125 Sherwood St.
Permit # 2014-00845

I am writing in regards to the construction going on at 125 Sherwood St. Permit # is 2014-00845.

A3.005

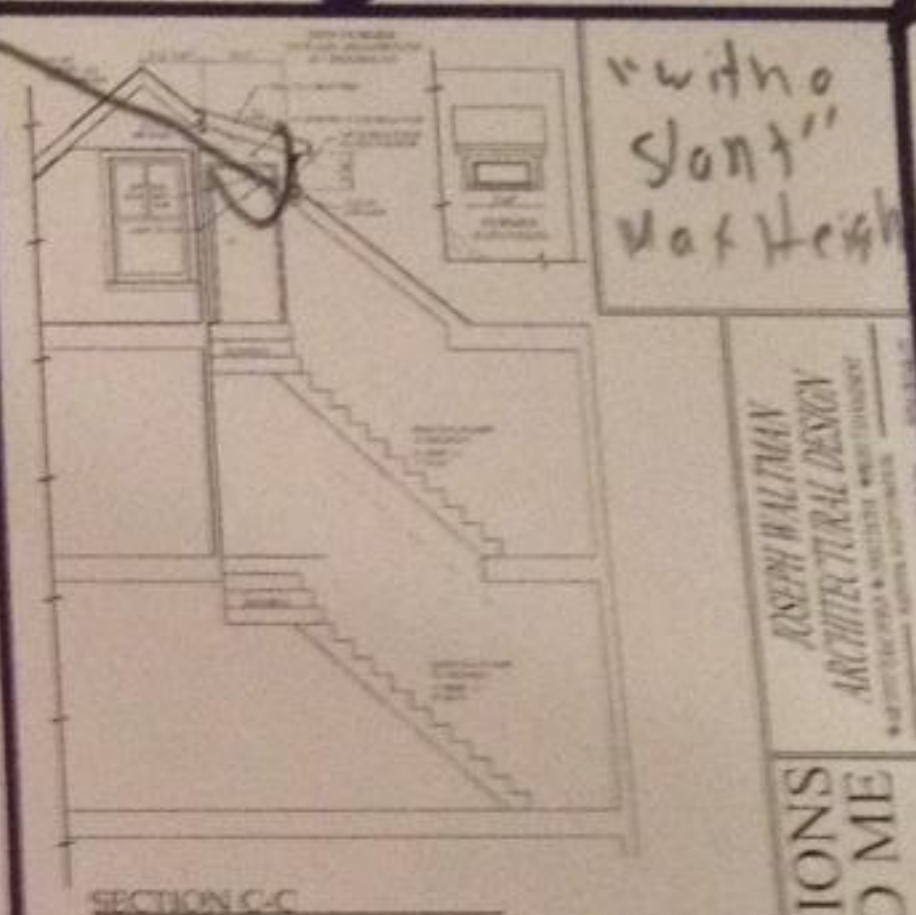
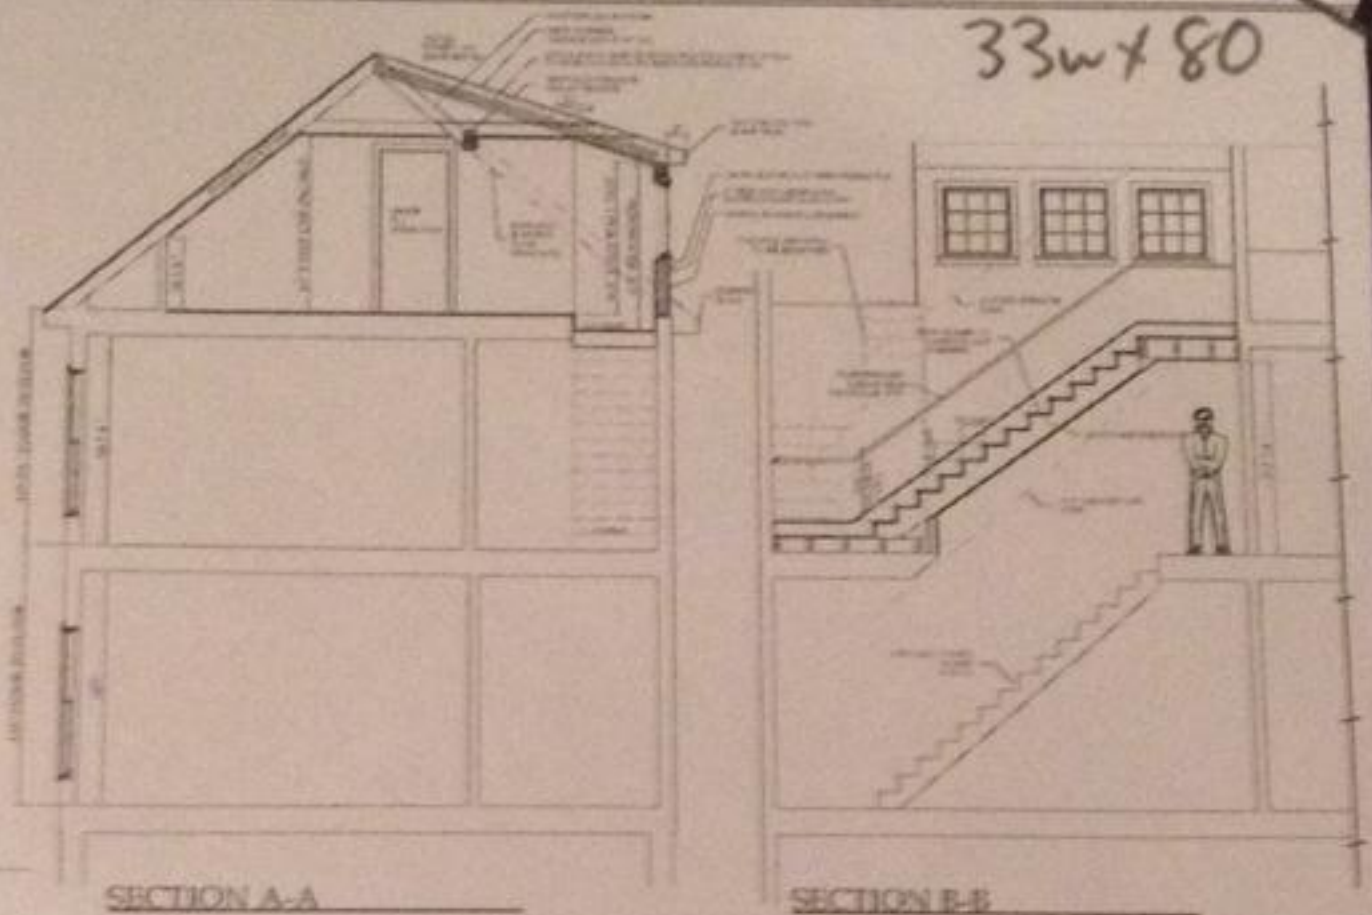
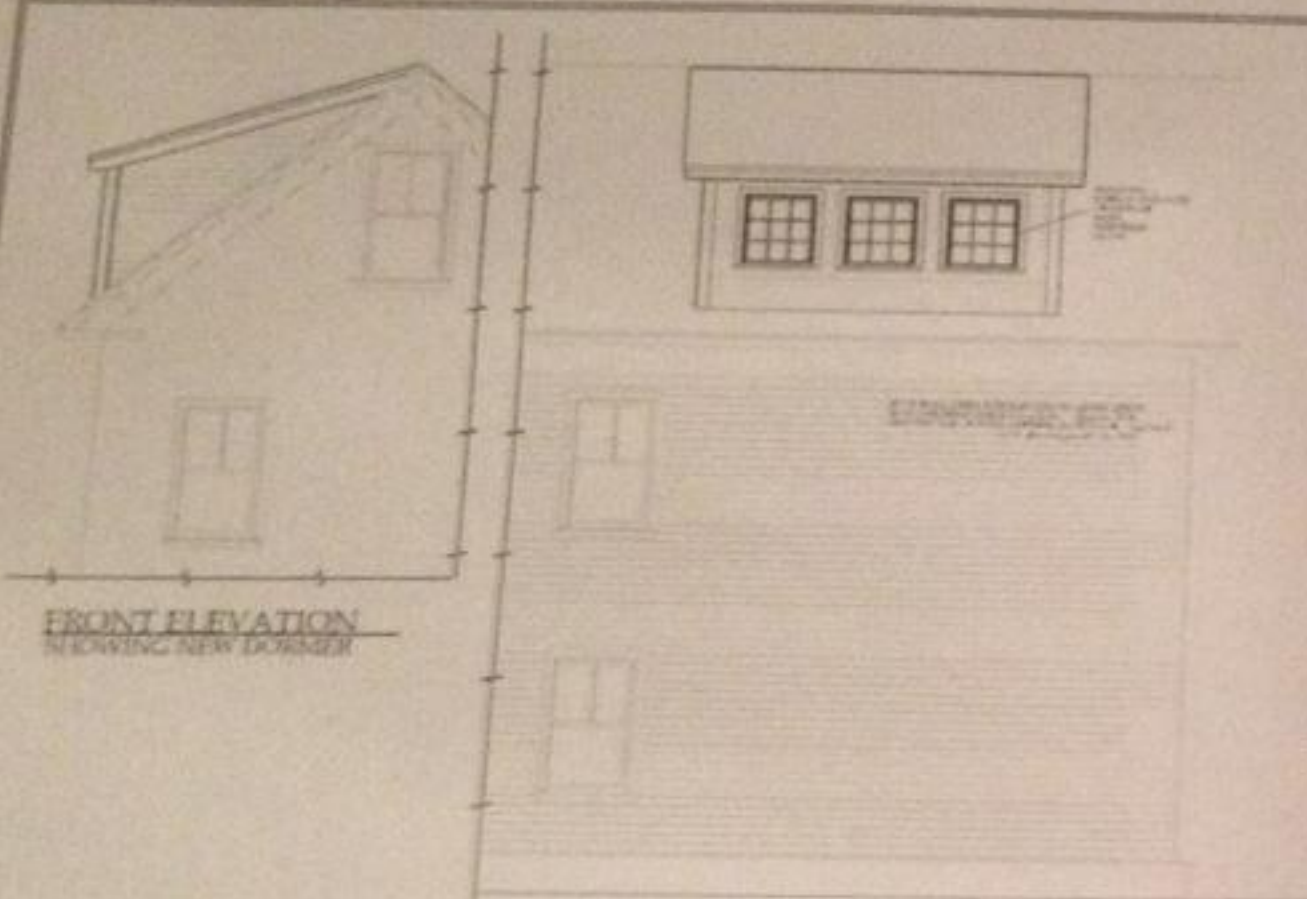
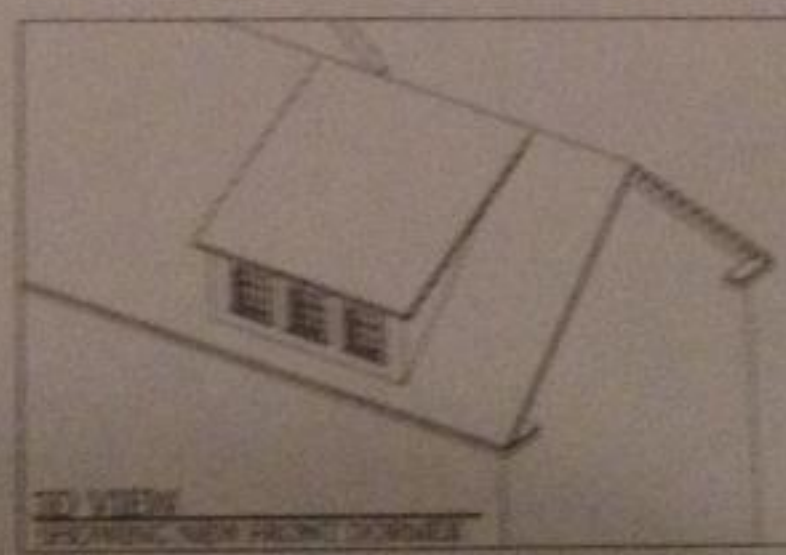
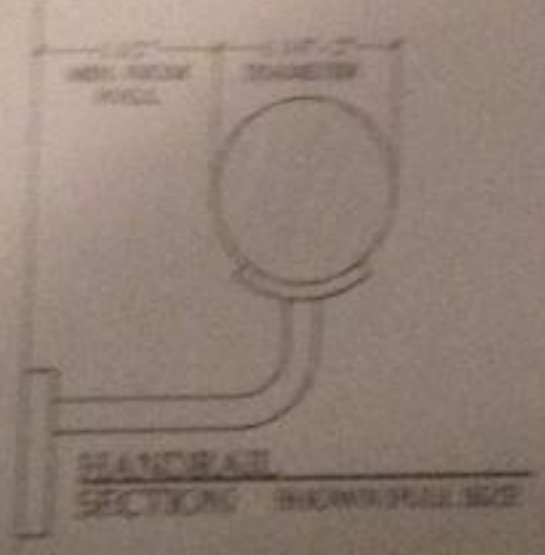
During the construction we have noticed a few alternatives to a second costly gable for the back stairwell. We have presented these alternatives to 3 inspectors and all three said they could be viable options they just need to be submitted so an addendum to the original work order could be made. First off the dormer for the front entrance is coming along and almost complete. The stairwell is huge and meets or exceeds current code allowing more than enough room for entry. The next area to be tackled is the rear egress. Here are two options which would be much preferred over the architectural drawings for many reasons.

1. Instead of raising the roof and inserting a dormer to provide adequate height for a fire door we would install a door at the bottom of the stairwell and leave the existing door as open space. The open space is 33" w x 80" h. There is a slant in the opening, but since there wouldn't be a door it would actually be a bigger opening than if a gable was installed and a door put in. This option is considered the best by the construction workers and homeowner and much preferred. A couple pictures have been provided. Picture 1 demonstrates the opening where the previous door existed and would be left open. Picture 2 is at the bottom of the staircase where the new door would be installed.

2. The second option would be to install a metal fire escape out of the bedroom window as to be a second fire escape if necessary. This option is much preferred over a second dormer but much less viable than option 1.
